**Subject:** B-1 Design Review – 23 Ocean Avenue

**Written by:** Caitlin Cameron, Urban Designer

**Date of Review:** Friday, July 8, 2016

FLOOR PLANS

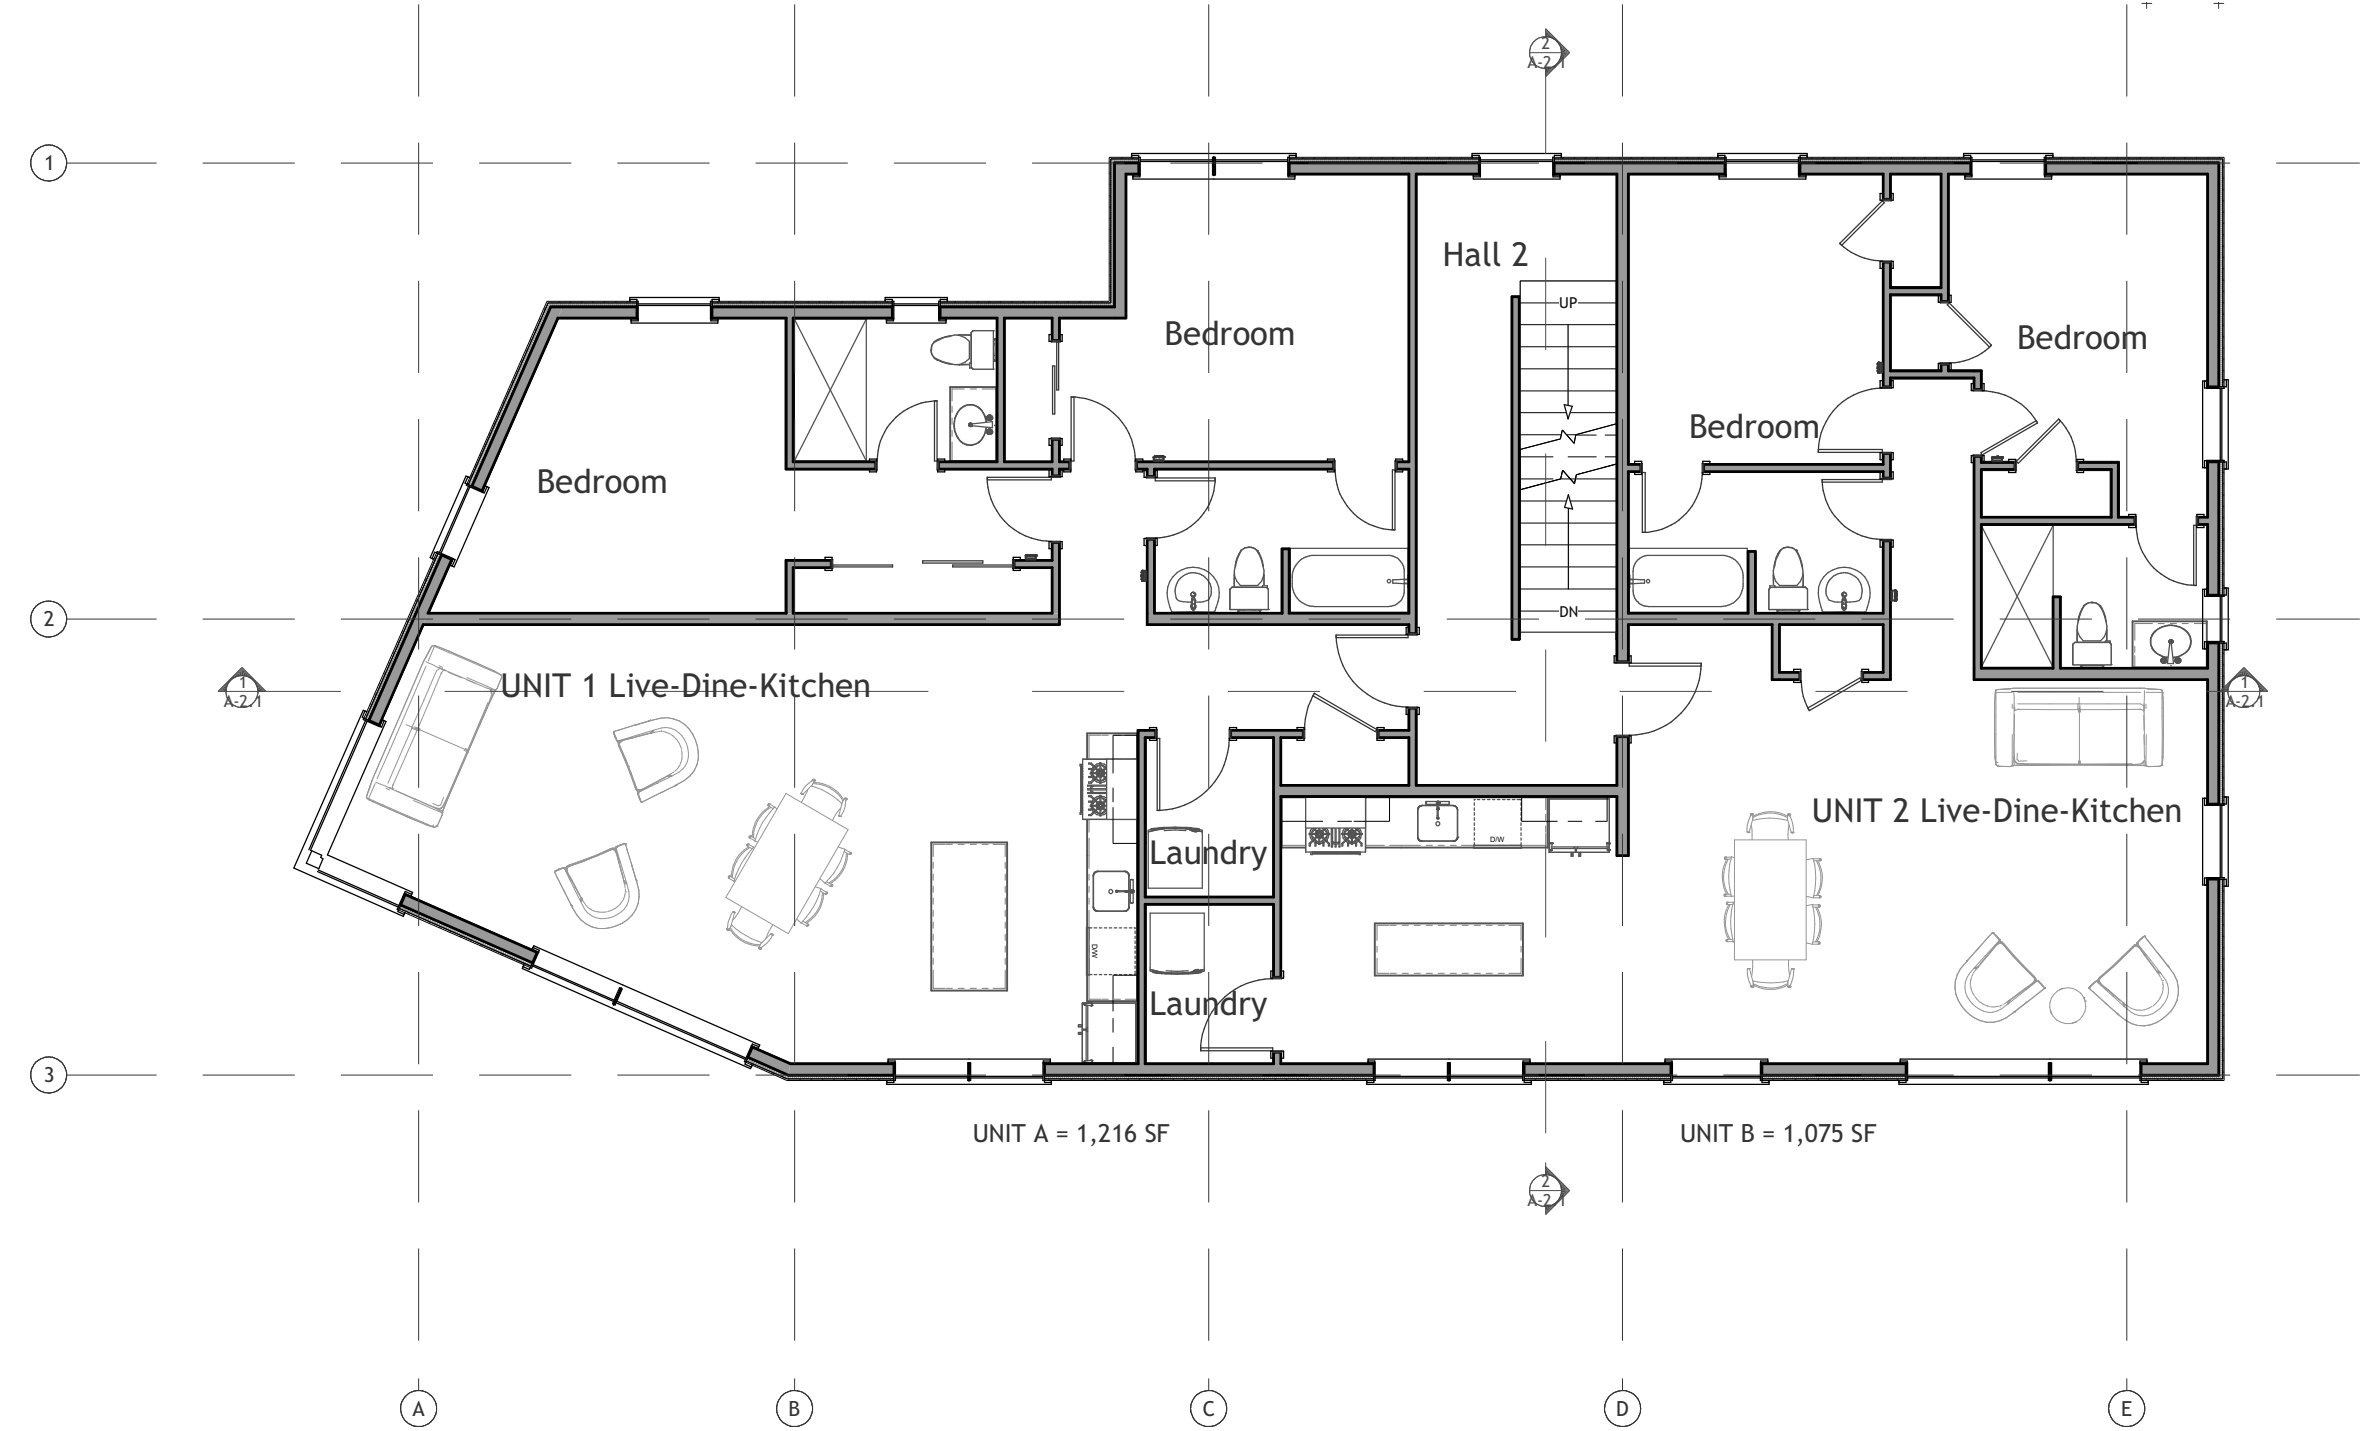
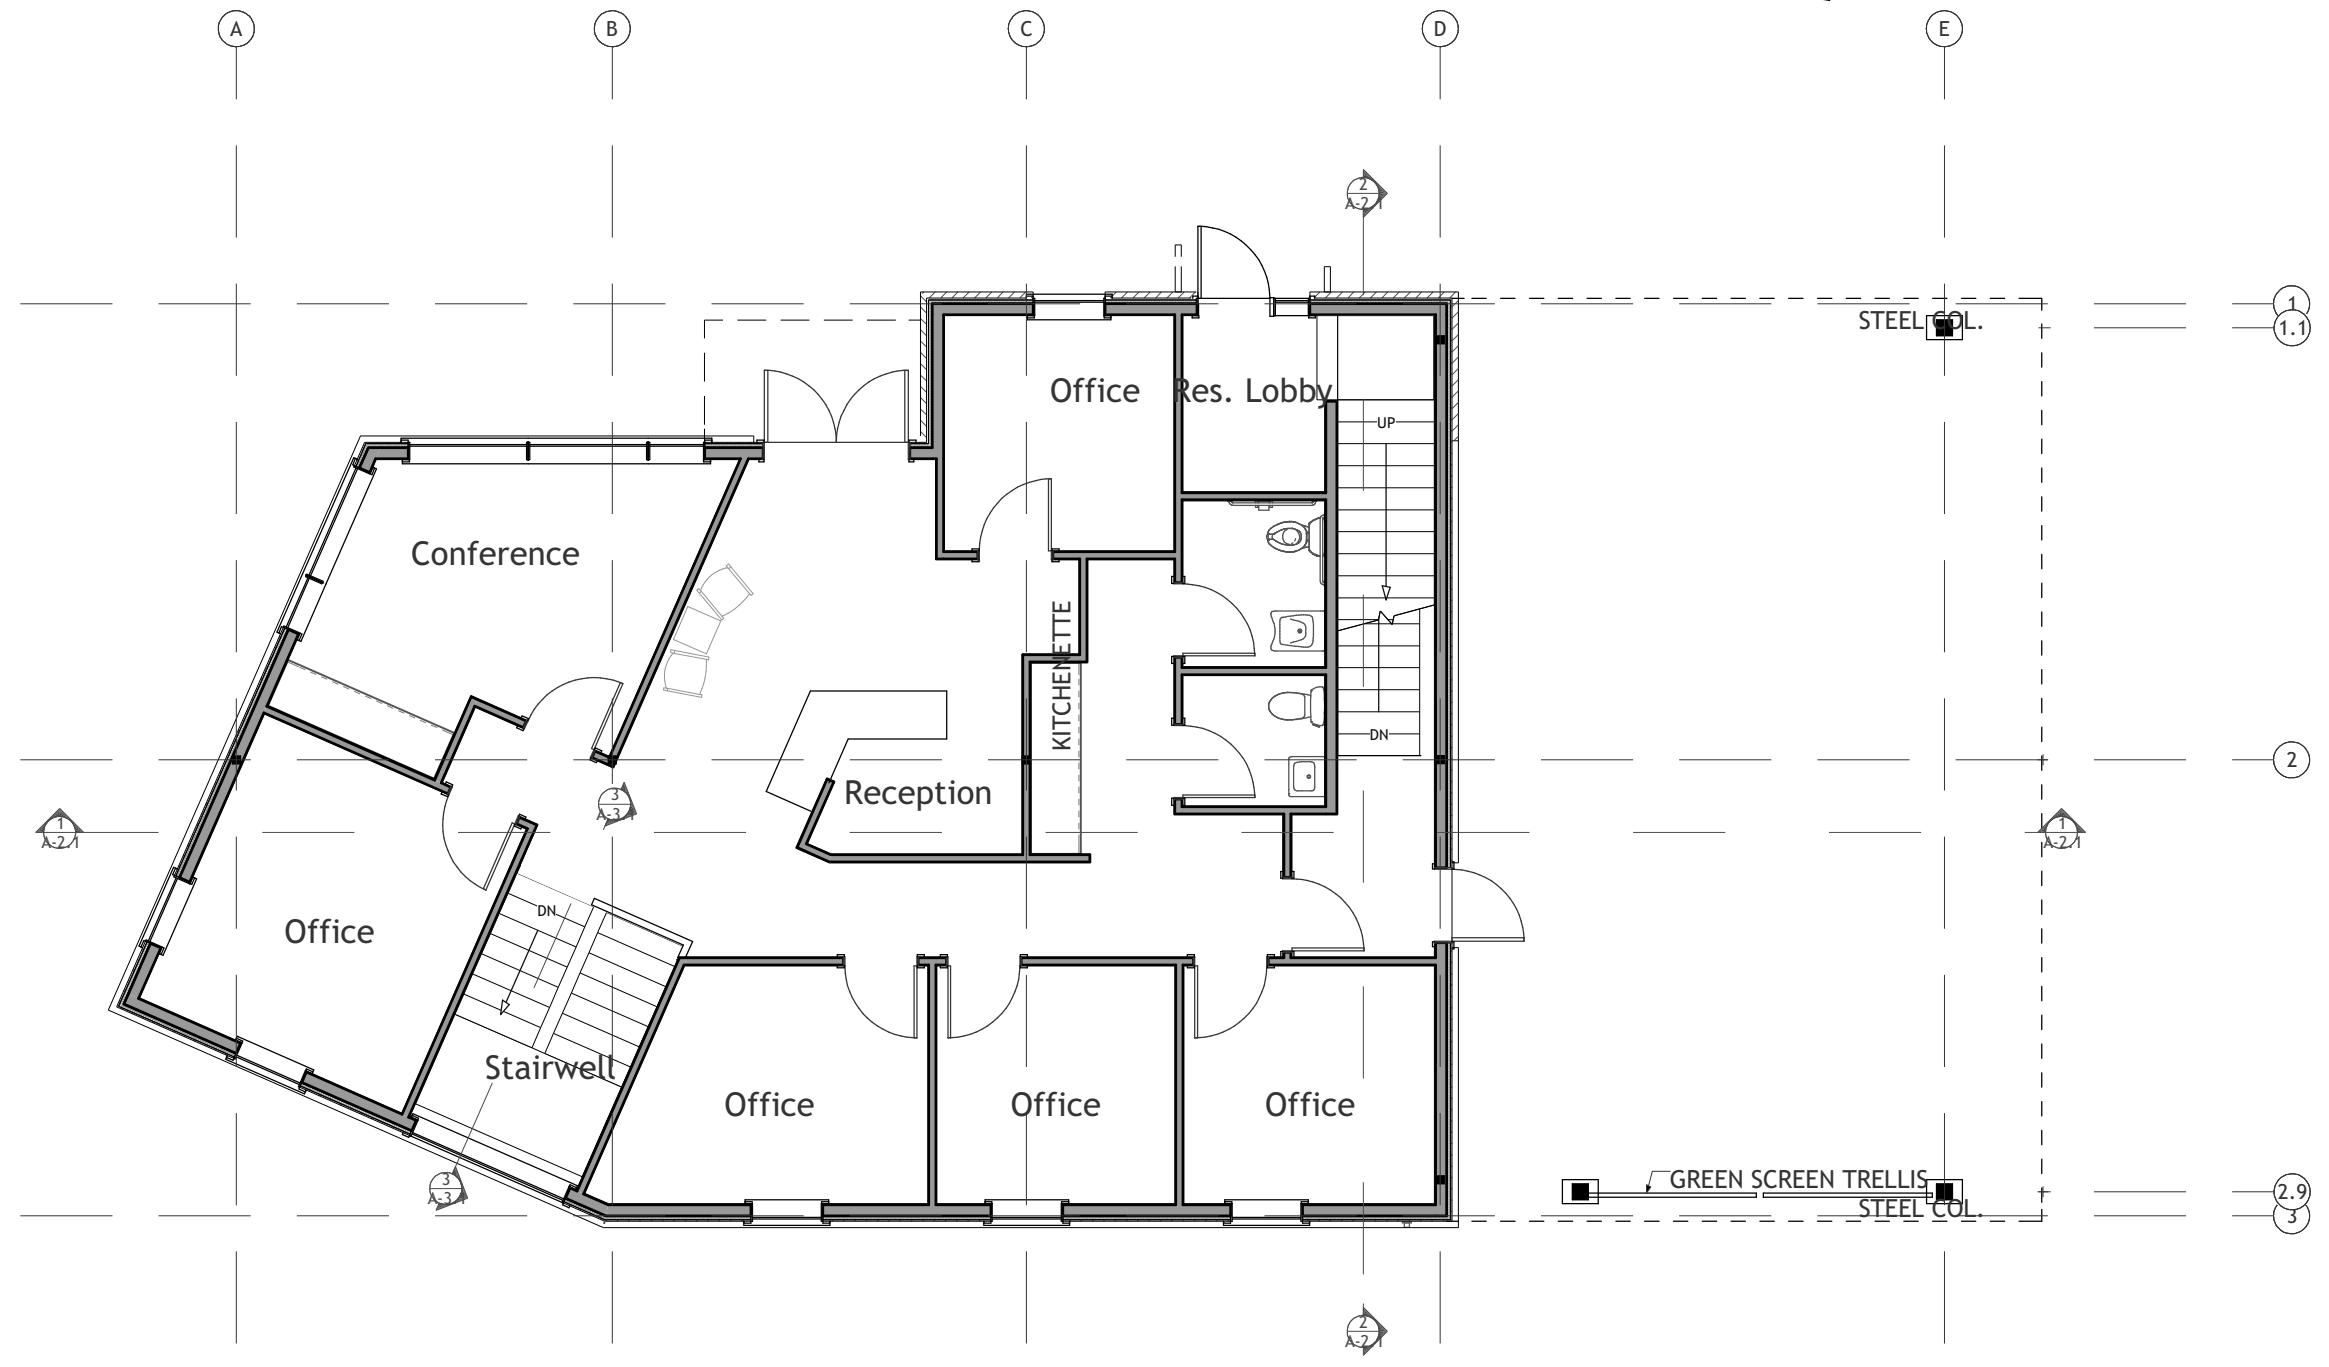
*Standard (1) c. Building Entrances* – We're concerned about visibility of entries from street – can office entrance be located closer to or on one of the streets? If not, visual cues from the street are needed, especially from the corner approach and indicating ADA route.

*Standard 3: Orientation of Buildings and their Entrances to the Street* – Entries to commercial spaces can be made more prominent with the use of features such as signage, canopies, or lights. Alternatively, entrance could be moved to face a street.

**A-2.2**

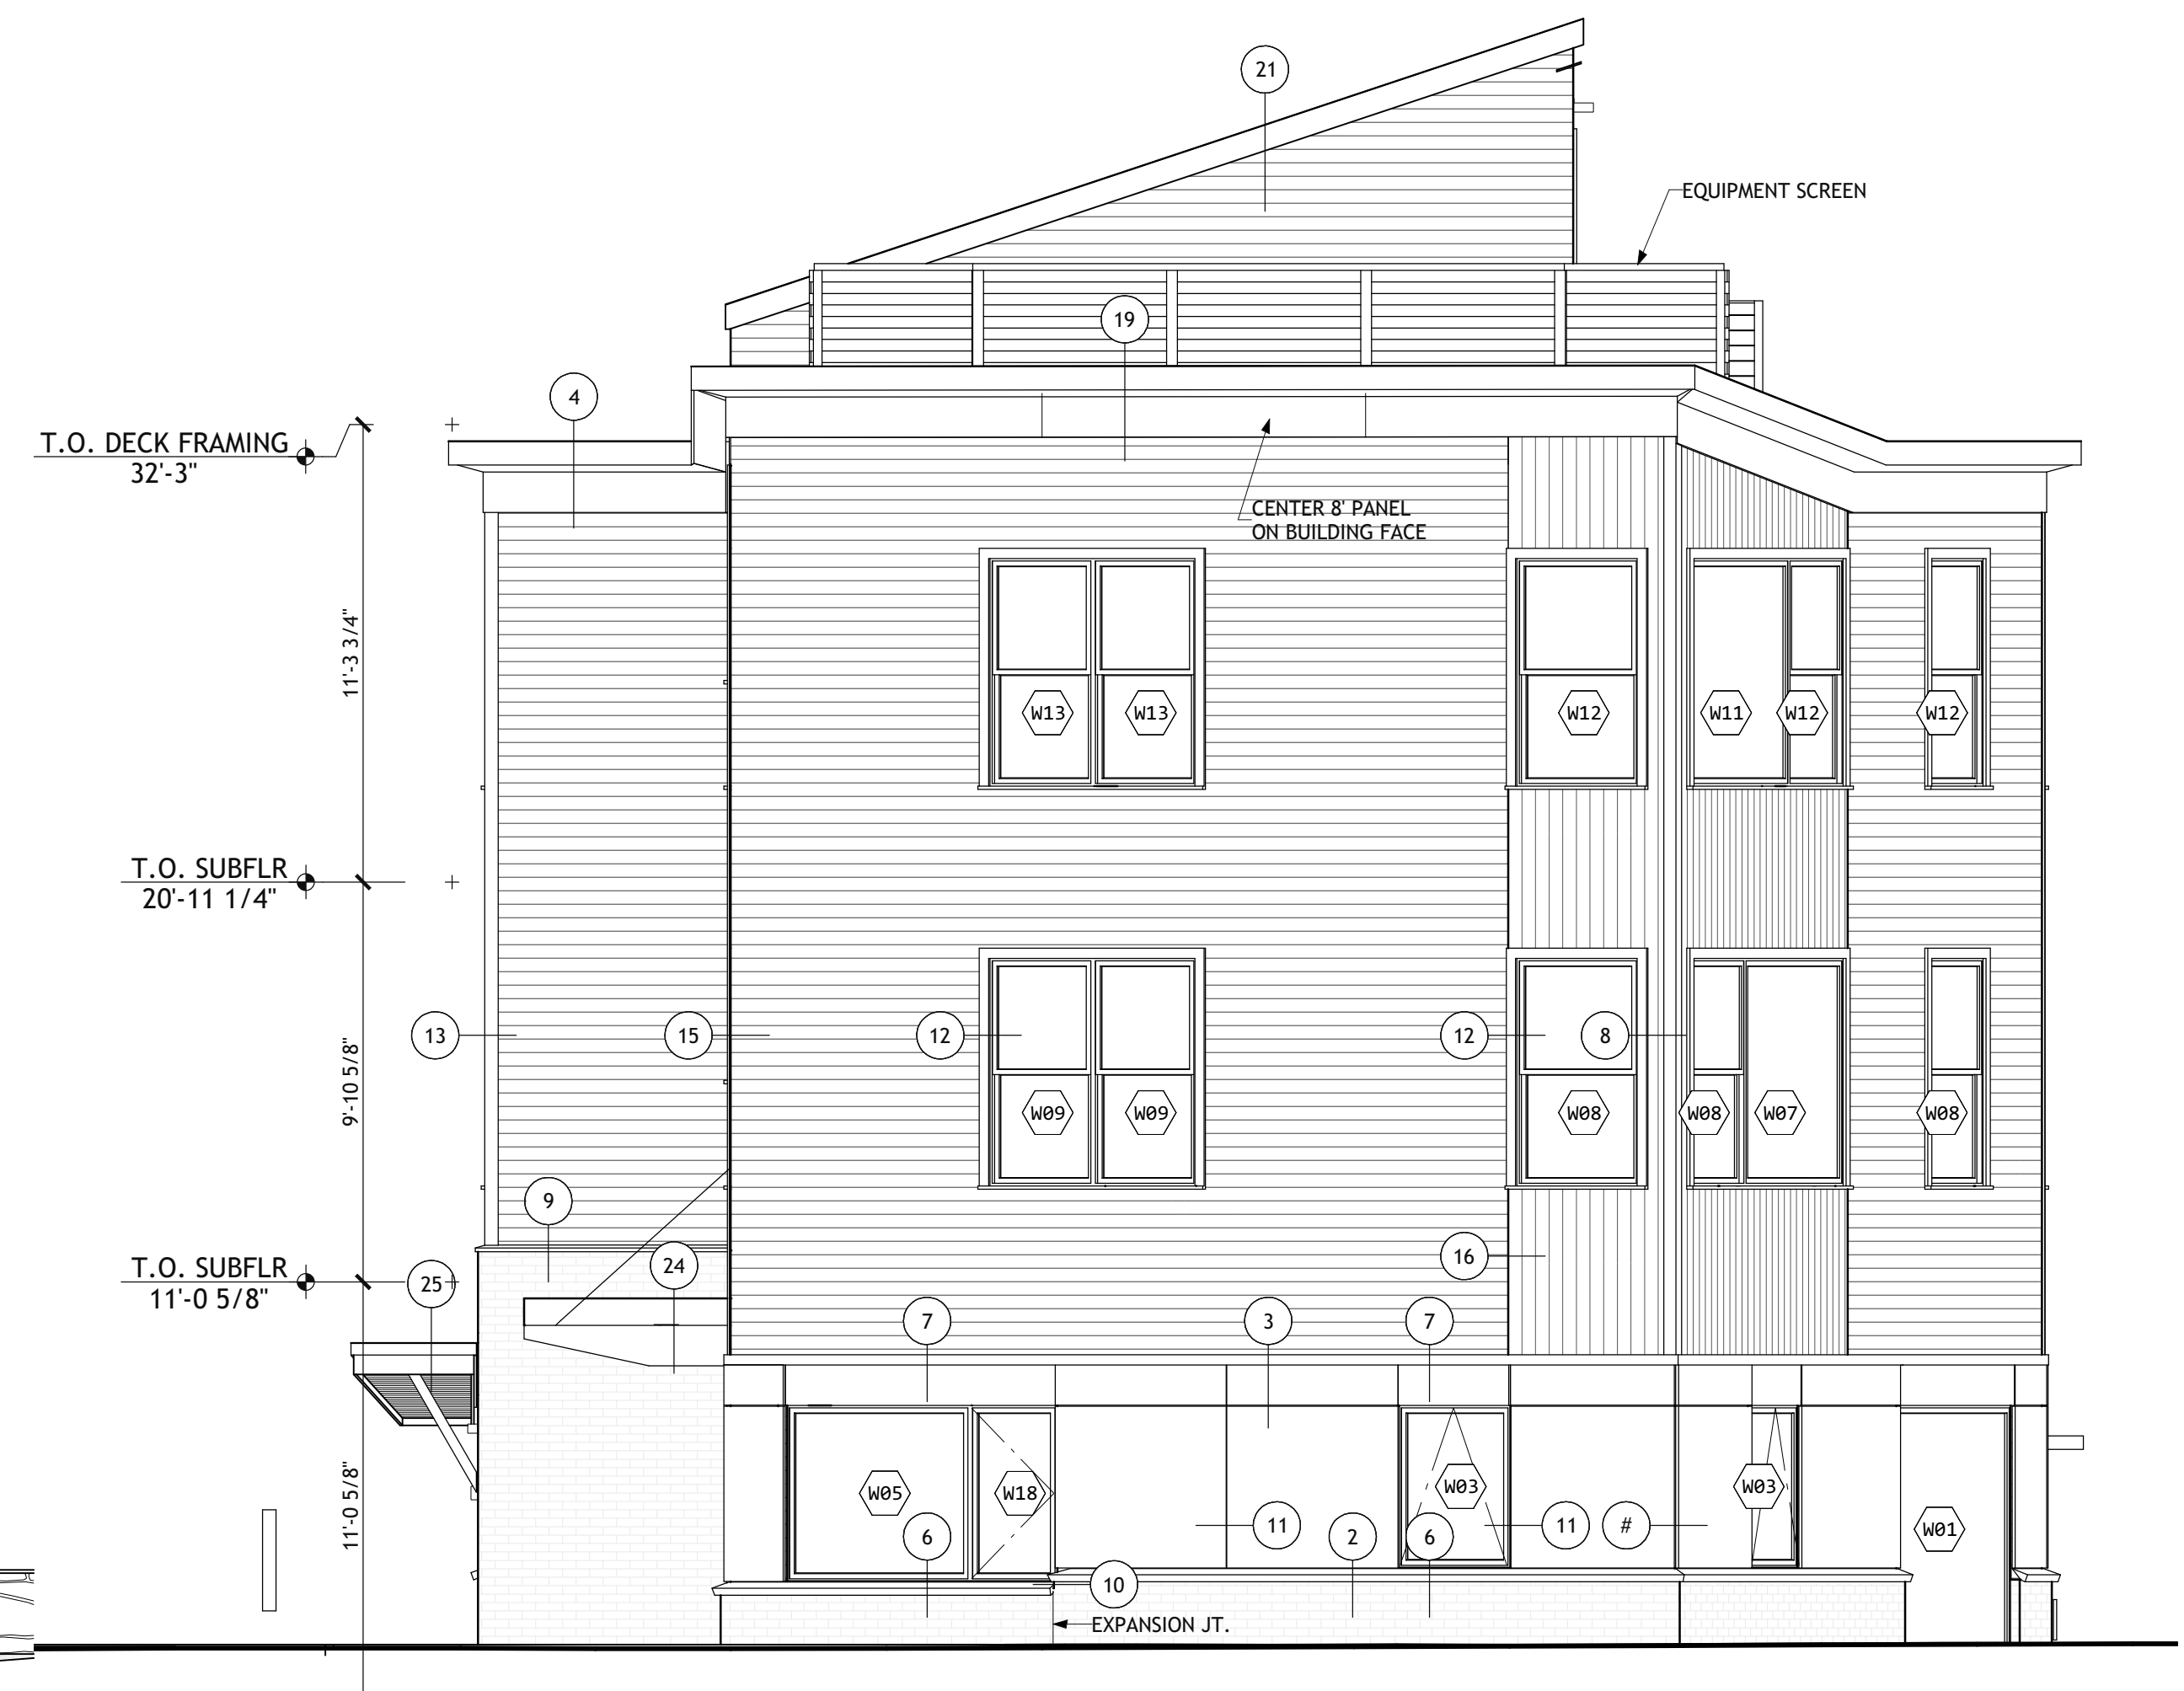
*Standard (1) d. Windows* – Façade character of the office portion of the building places fenestration with wrong emphasis – why are the largest windows at the stair instead of the active spaces? Corner approach should be made more open or active with fenestration. The office fenestration pattern versus the residential is not distinct enough – the upper floor residential should have consistent alignment and have a different character than the office.

*Standard (1) e. Façade Character* – Street-facing facades are oriented to and/or adjacent to public sidewalk. The office use should have a more distinctive façade character whether through floor delineation, fenestration patterns/sizes, and/or materials.

*Standard (1) g. Building Materials* – Metal siding is not found in either the residential or commercial context. Revise the material selection – fiber cement clapboard is recommended.

*Standard 1* – The street-facing façades provide a high level of fenestration and visual interest with façade variation, changes in materials, and projecting balconies. The form, scale, and roof line are consistent with and complement the surrounding residential context. Adjust fenestration on corner approach to distinguish office from residential uses. Window proportions could be adjusted to reflect context.
